Rezoning Transportation Analysis

Petition Number: 2022-179

From: Jake Carpenter, PE

Date	Description
3-22-23	First Review (JP)

TECHNICAL DATA SHEET

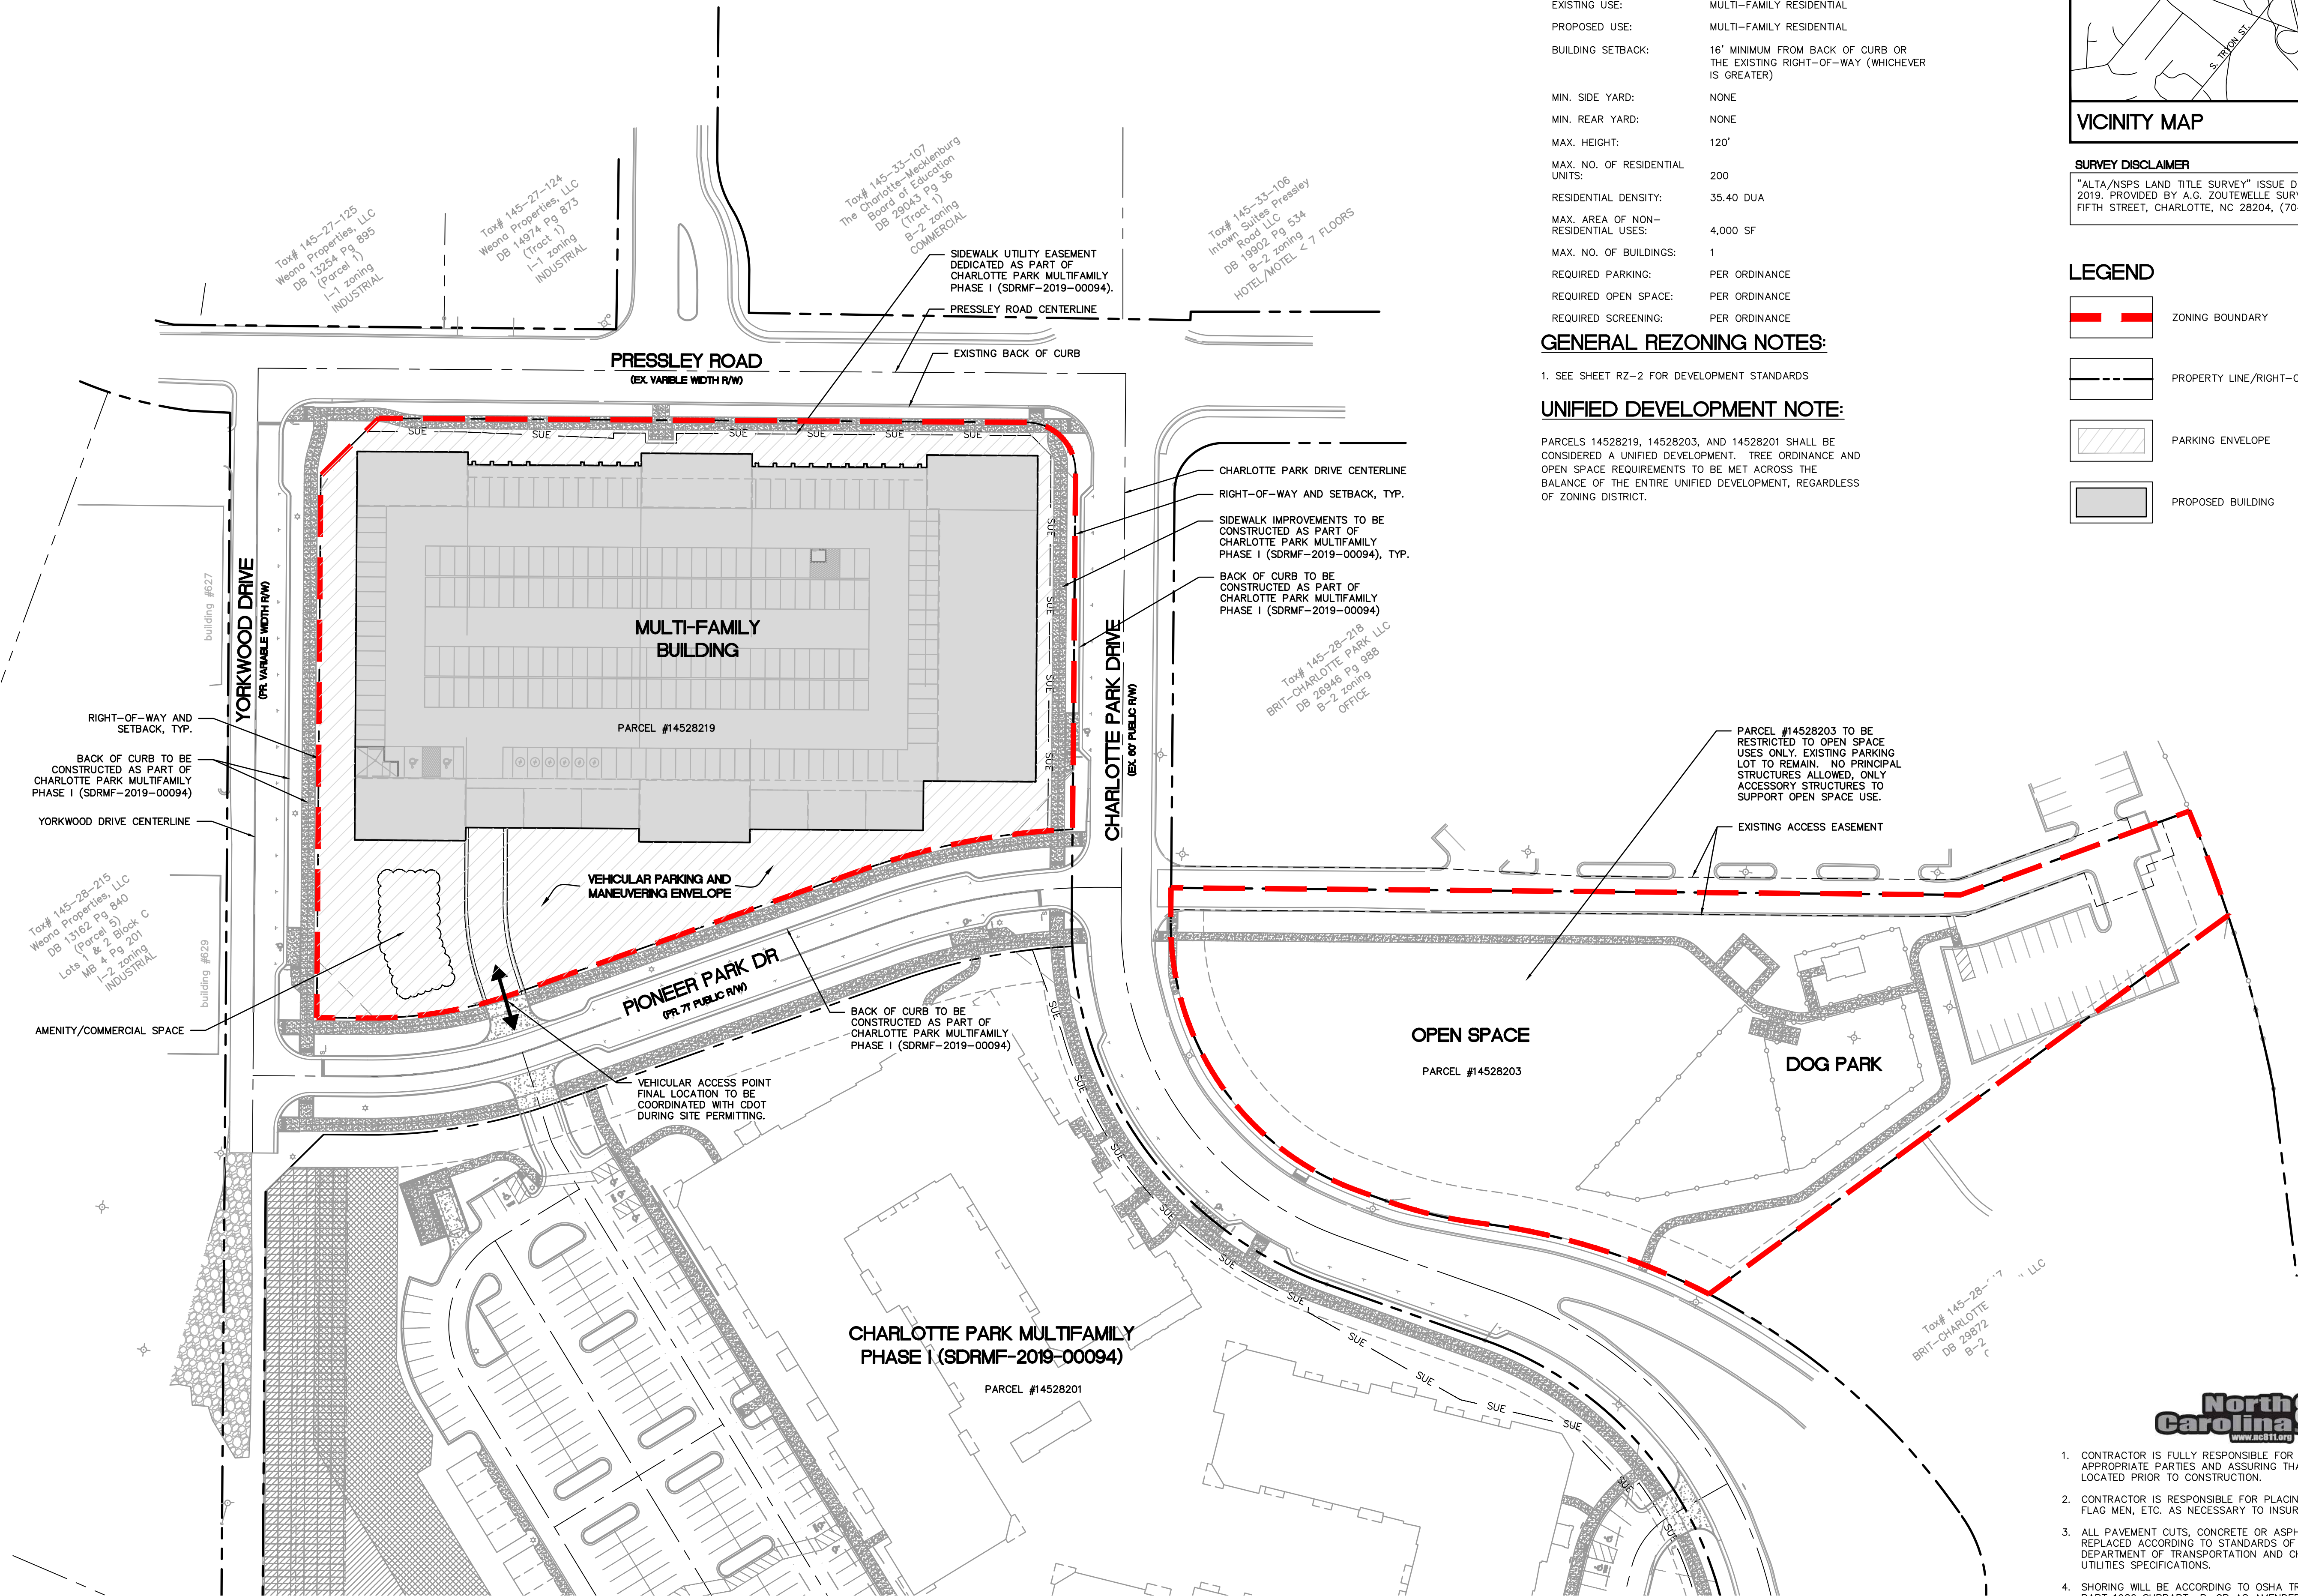
- Label and dimension the back of proposed and existing curb and gutter from the centerline for each road on the site plan.

4. **Revise site plan label each public street with the applicable CDLSM standard.**

5. **Revise site plan to remove notes regarding the construction of frontage improvements by others. Construction on these improvements by others is ok, but they will need to be constructed by the petitioner if not installed by others at the time of CO application.**

6. Revise site plan to dimension and label all sidewalks and planting strips along the petition's public road frontages. In addition, provide upgraded sidewalk along petition frontage of Charlotte Park Drive along the proposed open space if substandard.
7. Coordinate with NCDOT regarding the alignment of a proposed interstate ramp per the I-77 feasibility study.
